# V1Construction Drawings.pdf Markup Summary

OUTLOOK POWERS & GRINNELL
 SIGNAGE & STRIPING PLAN

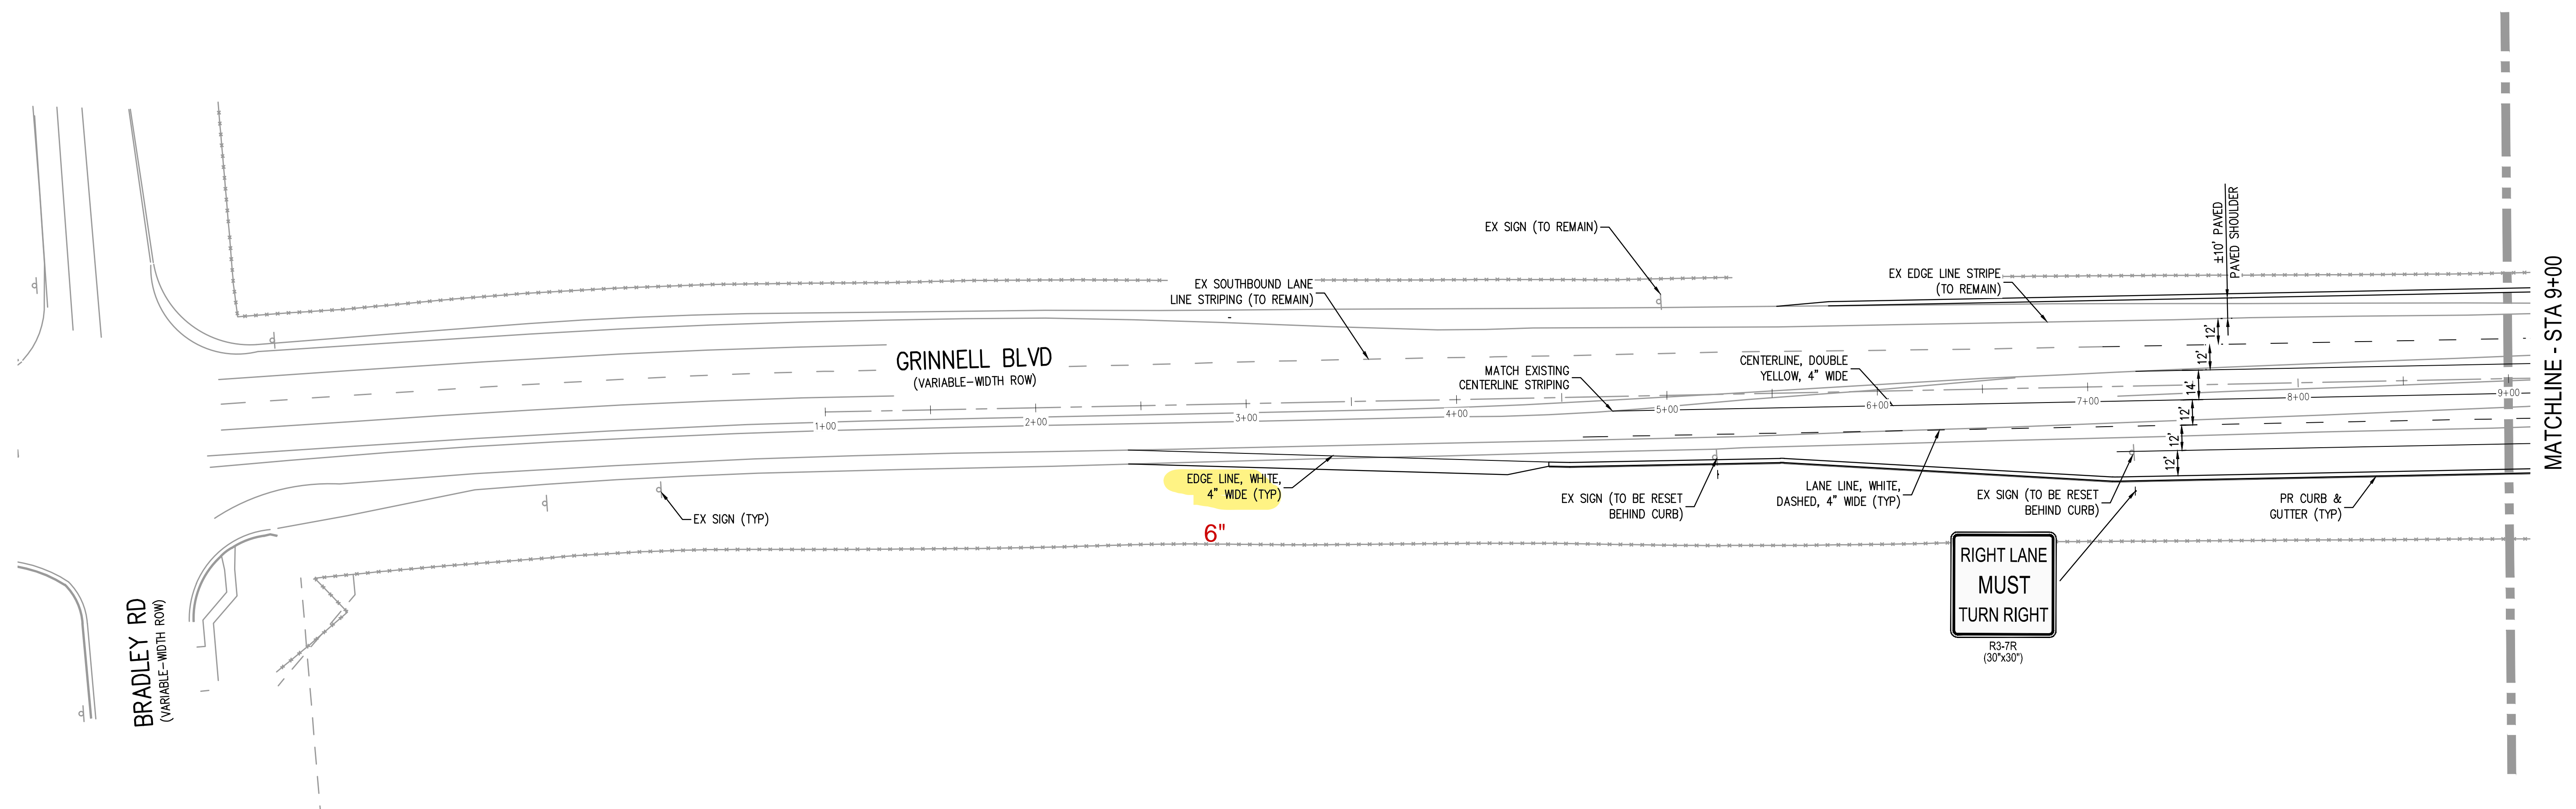
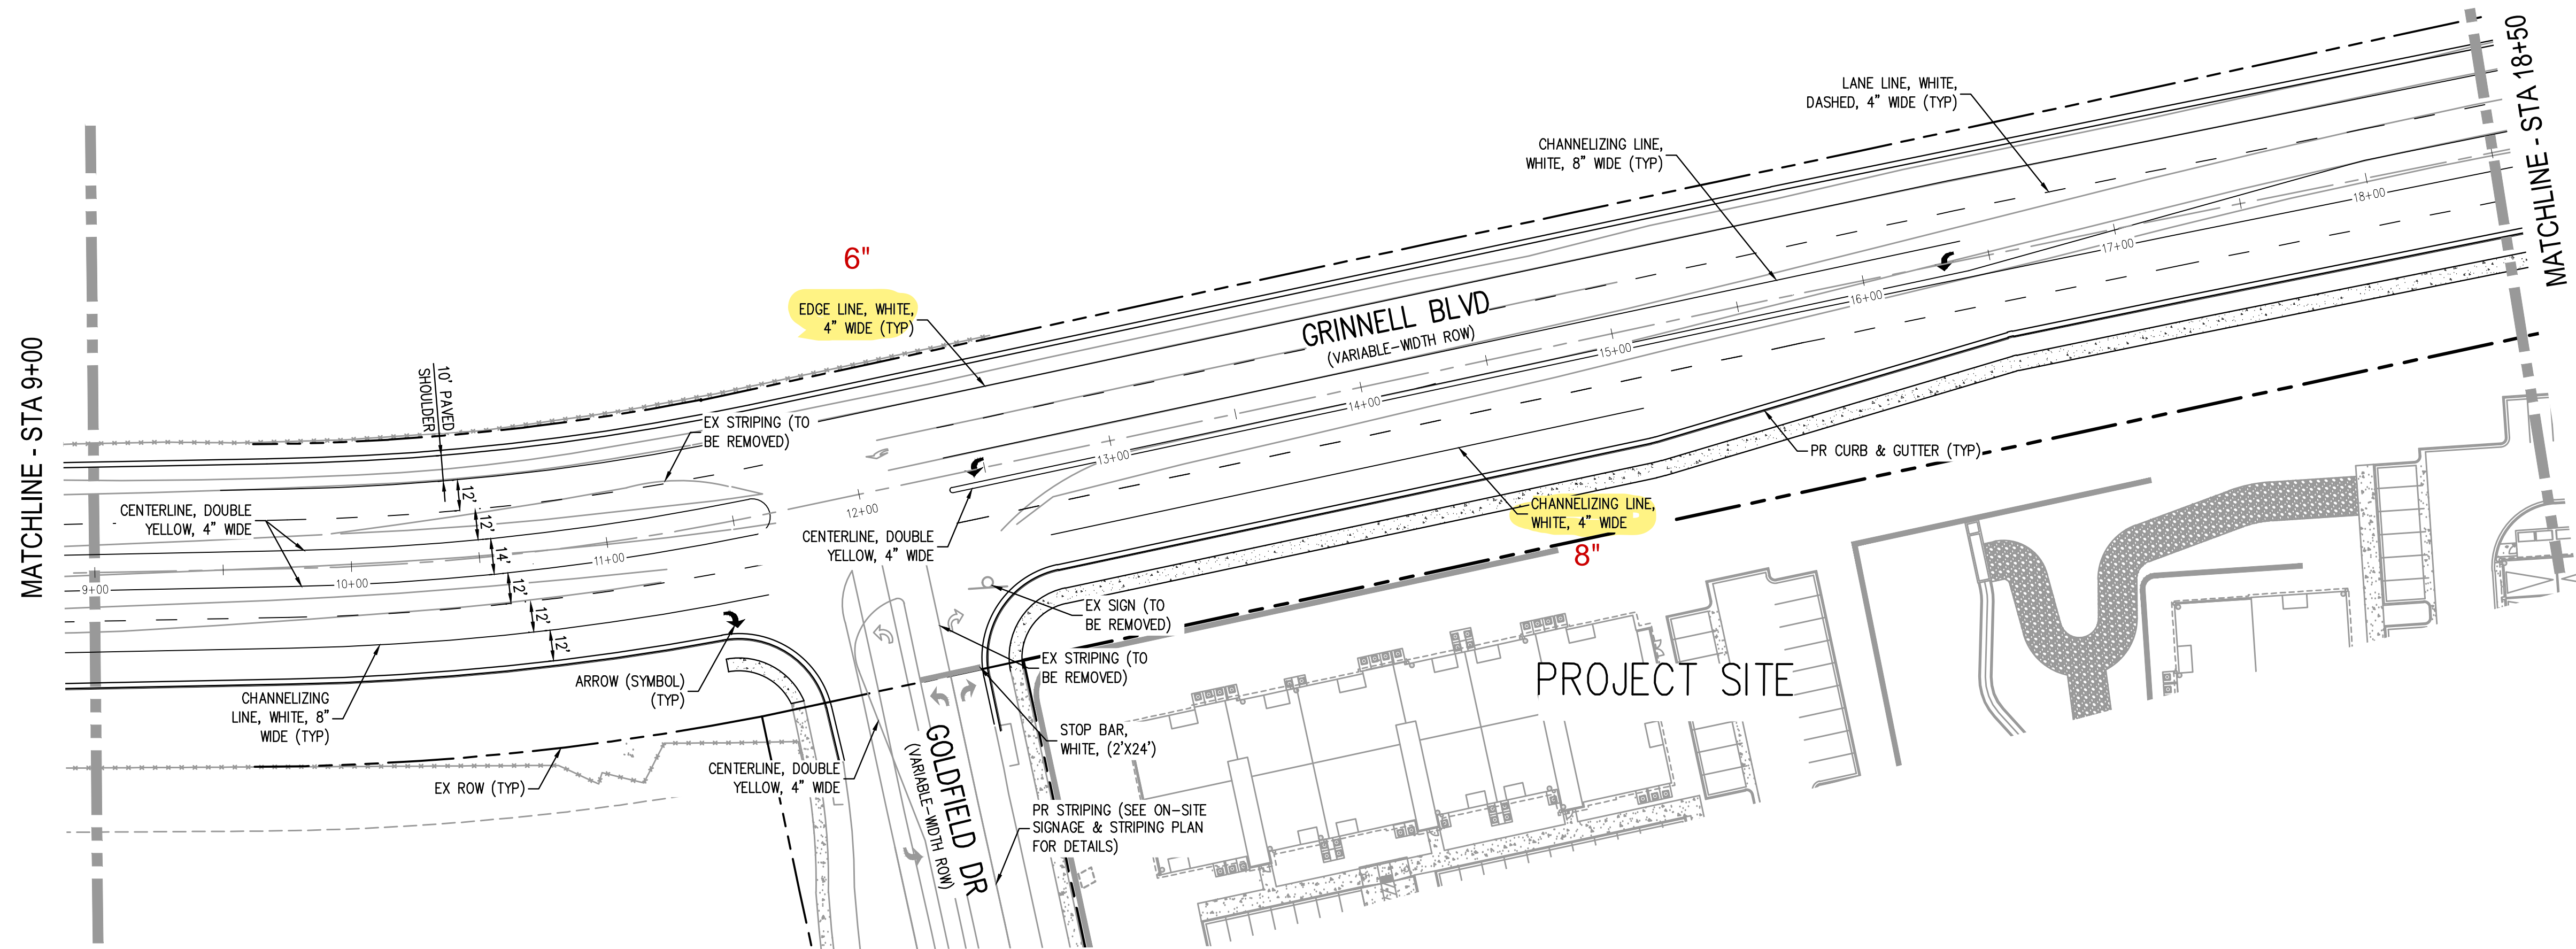
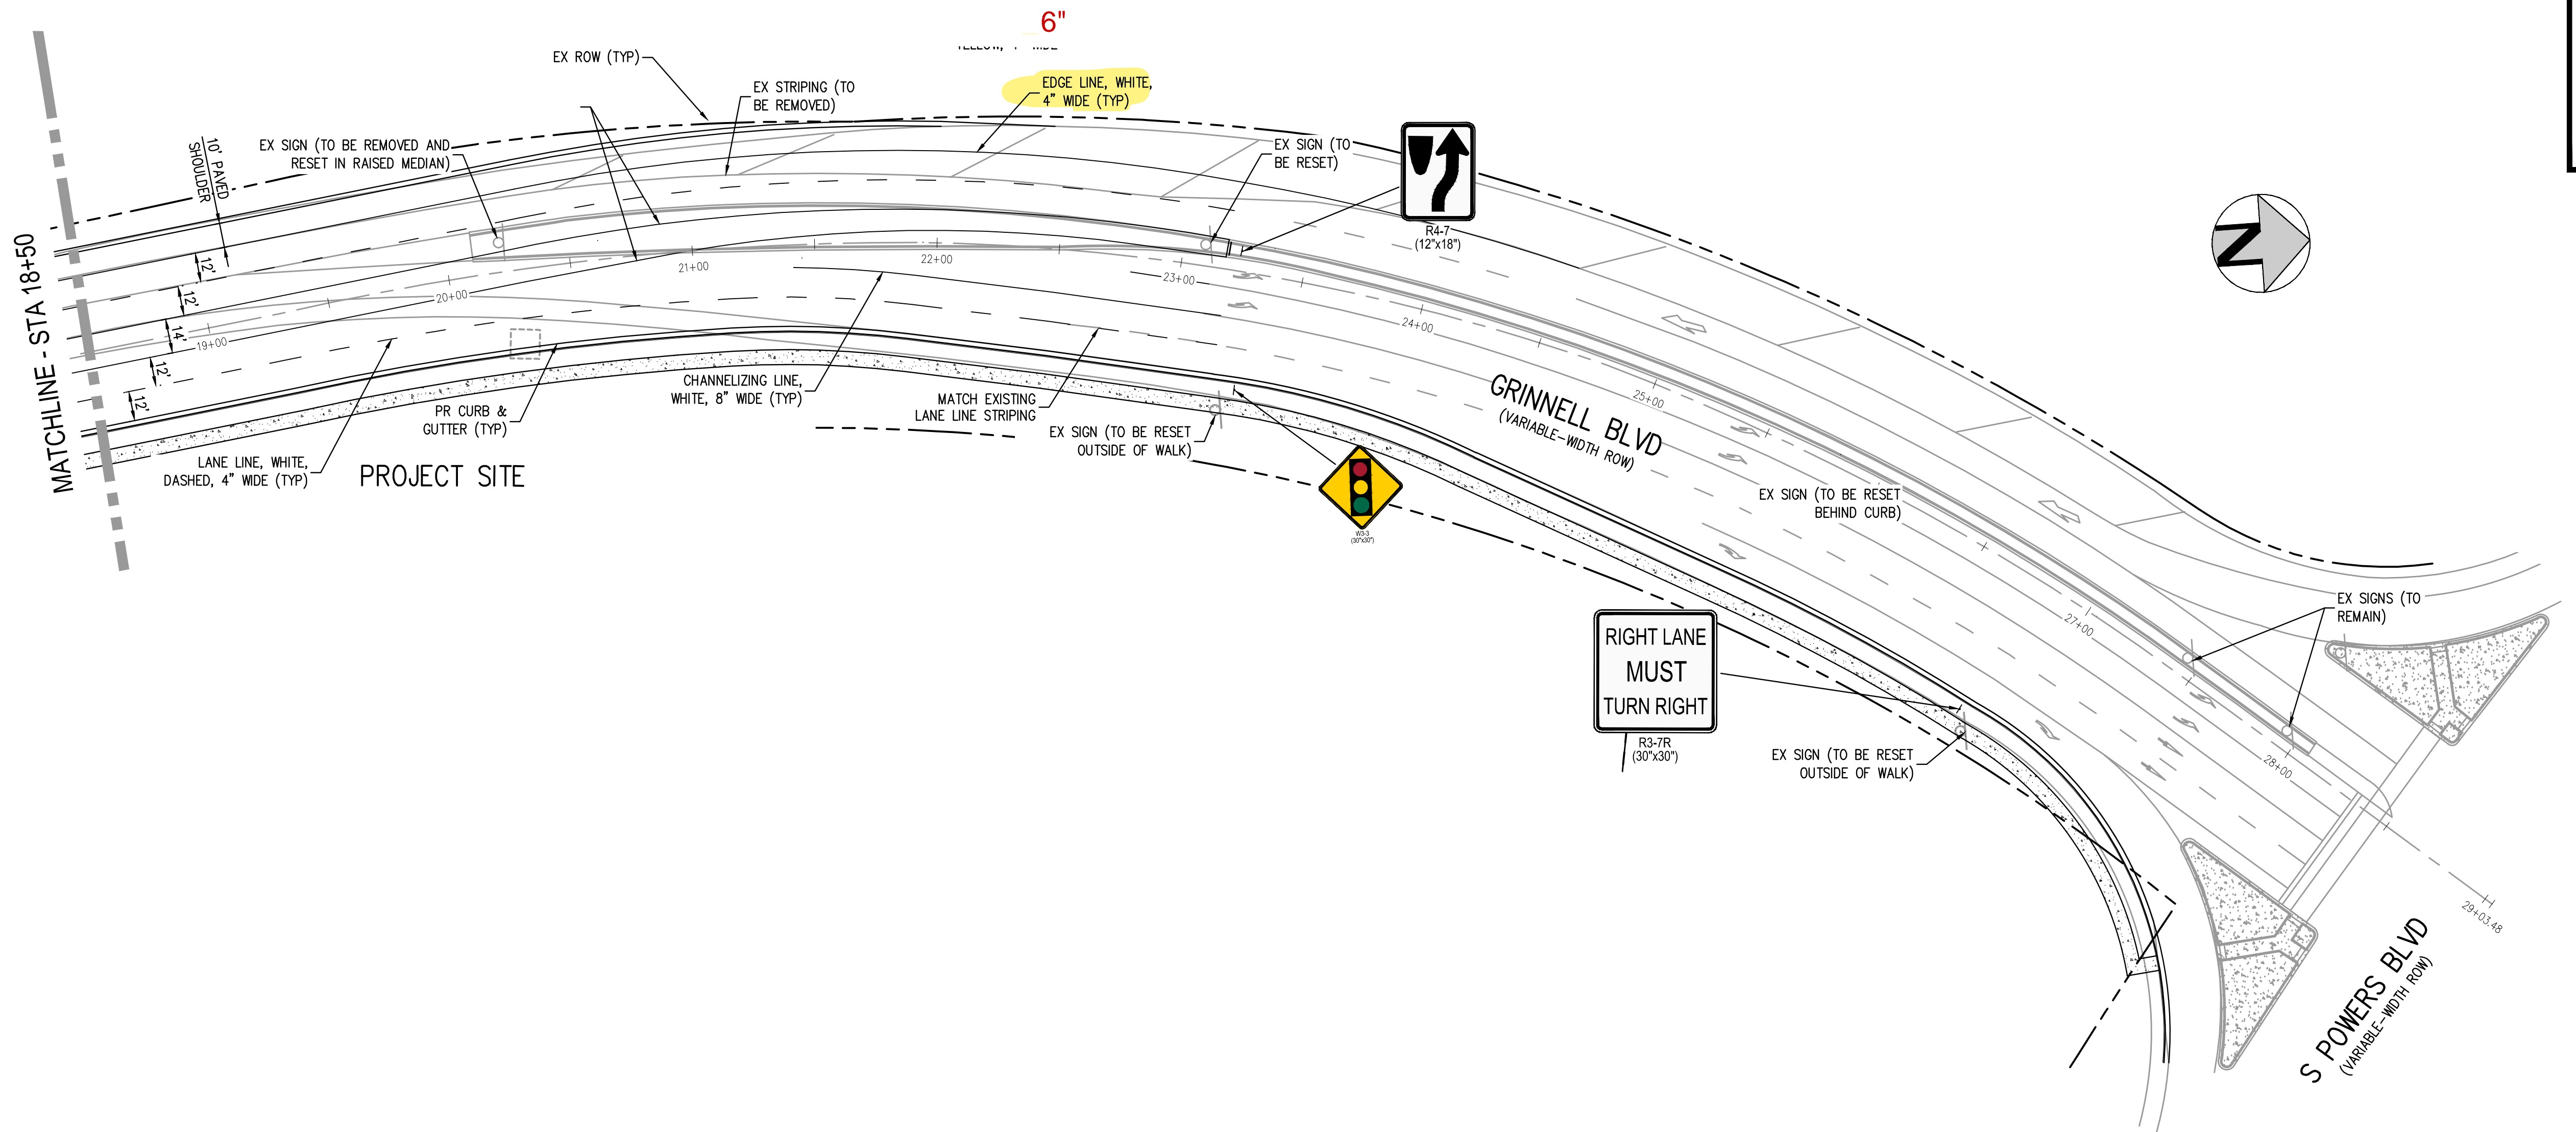
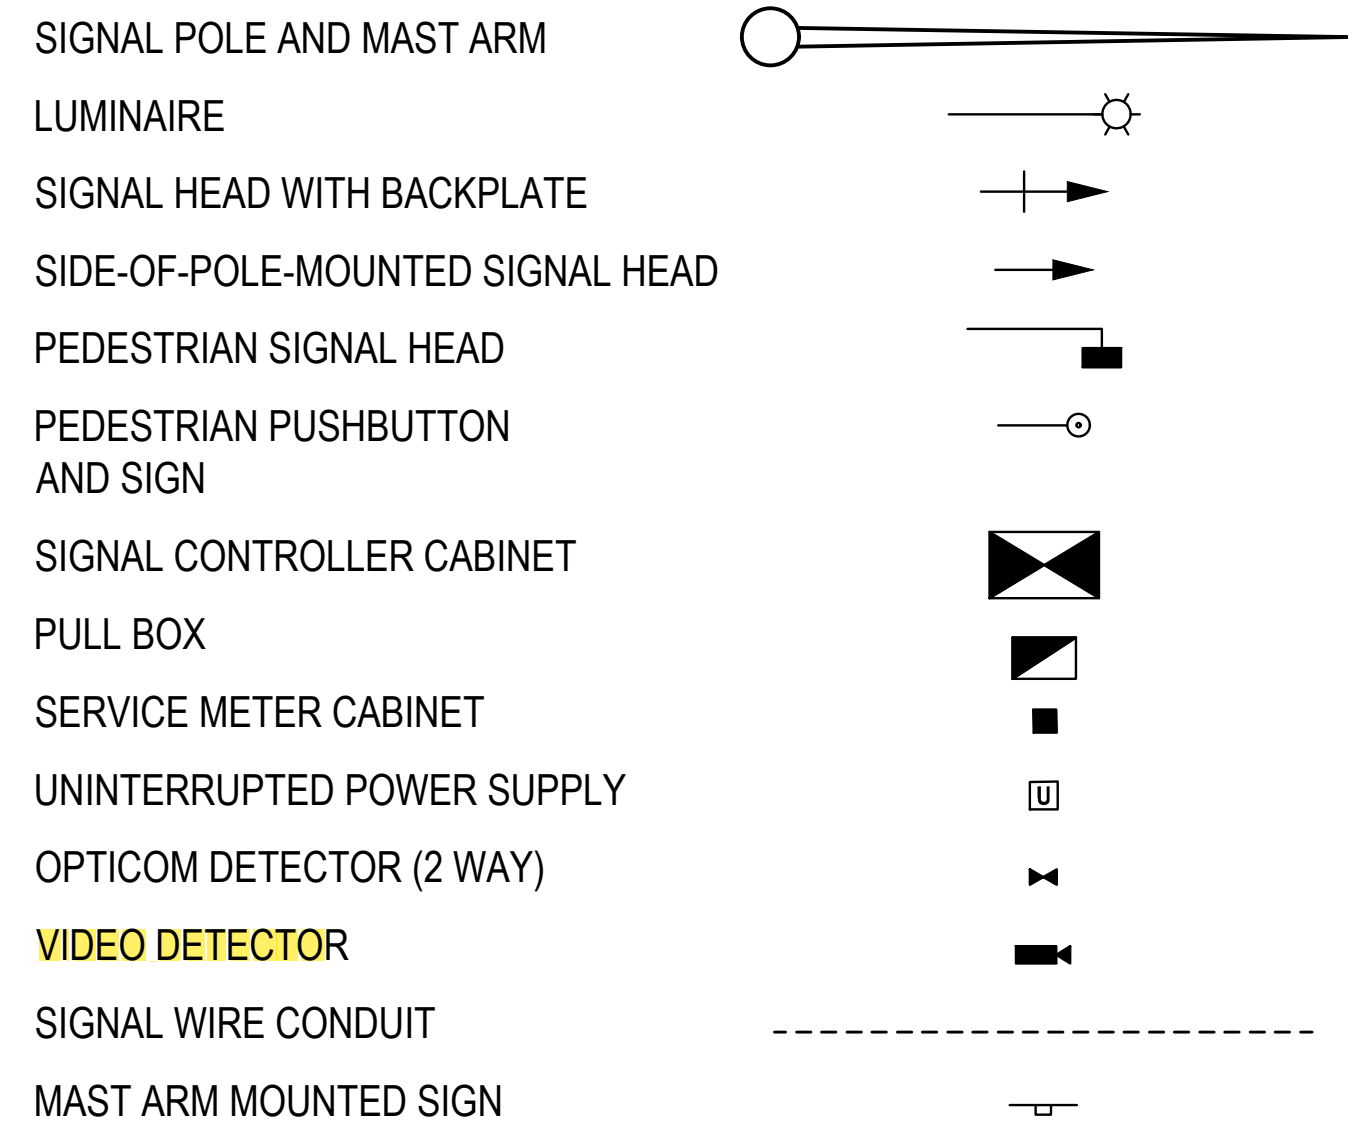
Show station location

Show crosswalk

Show pedestrian ramp

label dashed box

install crosswalk striping per signing & striping note #11

Revise to 8" channelizing line

Add accel lane lines

Add 8" lane drop lines

provide a lane end merge left sign (W4-2)

Adjust striping and flatten out the north side. Run Autoturn template to determine the required radius.

**Subject:** Callout  
**Page Label:** [28] 28 SIGNAGE & STRIPING PLAN  
**Author:** dsdlaforce  
**Date:** 6/20/2023 11:08:14 AM  
**Status:**  
**Color:** ■  
**Layer:**  
**Space:**

Add Stop Bar at the signalized intersection
